# KITTITAS COUNTY DEPARTMENT OF PUBLIC WORKS

## MEMORANDUM

TO: Community Development Services  
FROM: Taylor Gustafson, Environmental/Transportation Planner  
DATE: February 14, 2019  
SUBJECT: Ackroyd CB-19-00001

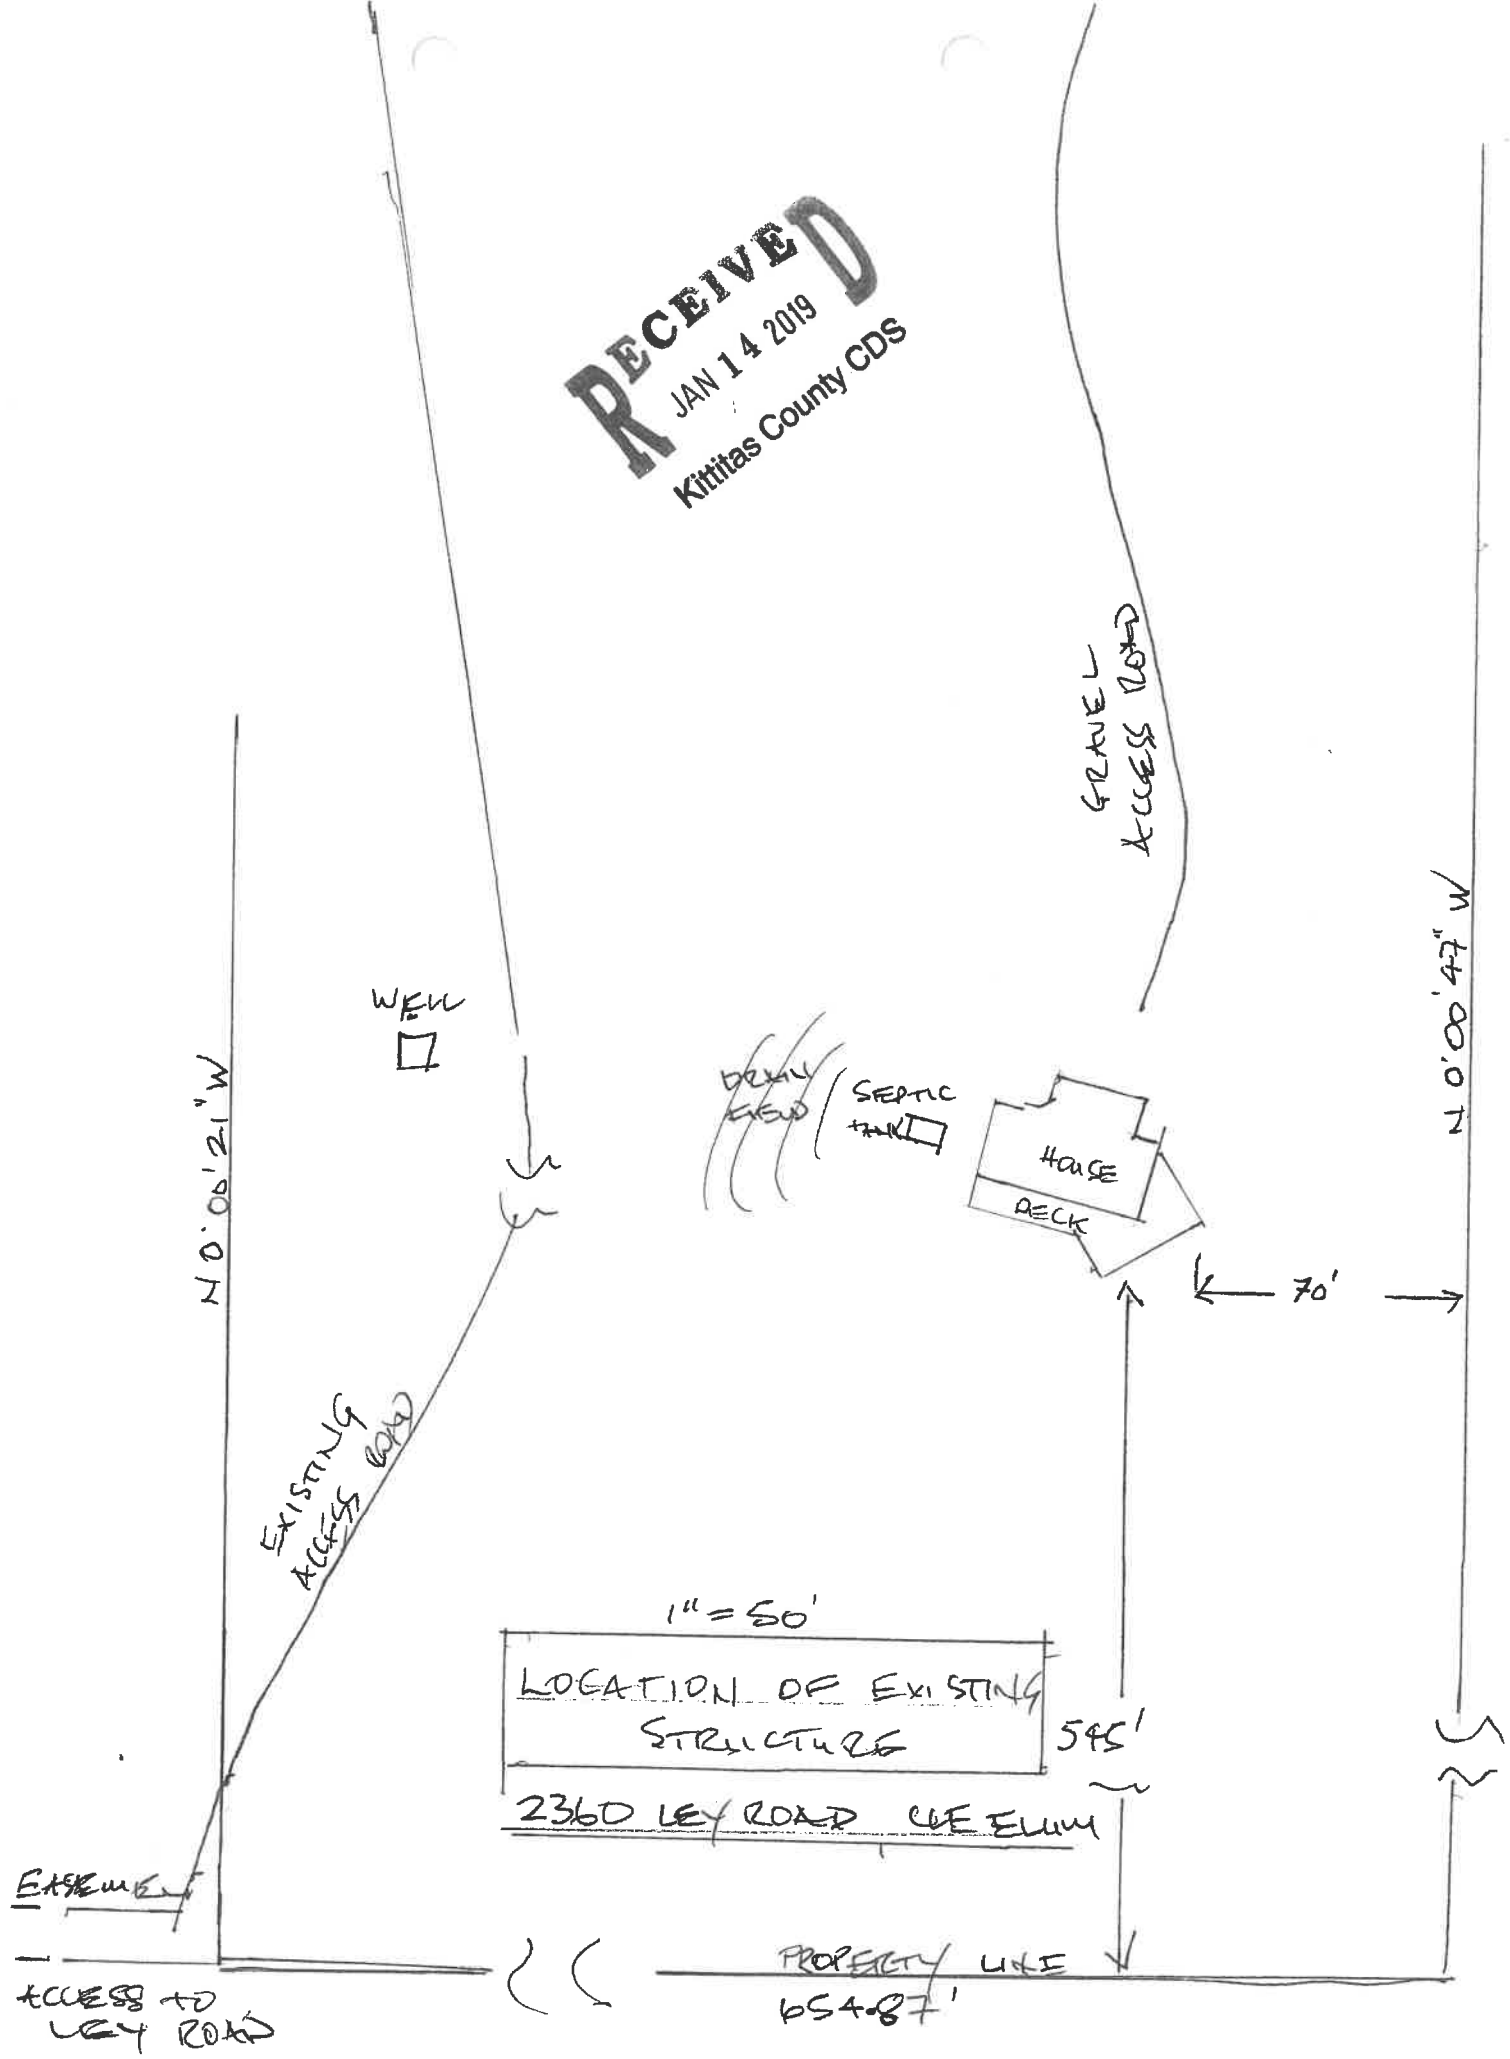
1. Access to property shall be from existing approach onto Ley Road.
2. The private roads accessing the parcel combination will be at a minimum subject to the 2015 Road Standards for a single use driveway. These standards will apply from the location where the access road to the property intersects with a publicly maintained road up to a proposed structure.
3. Any further subdivision, residences or lots to be served by proposed access may result in further access requirements. See Kittitas County Road Standards.
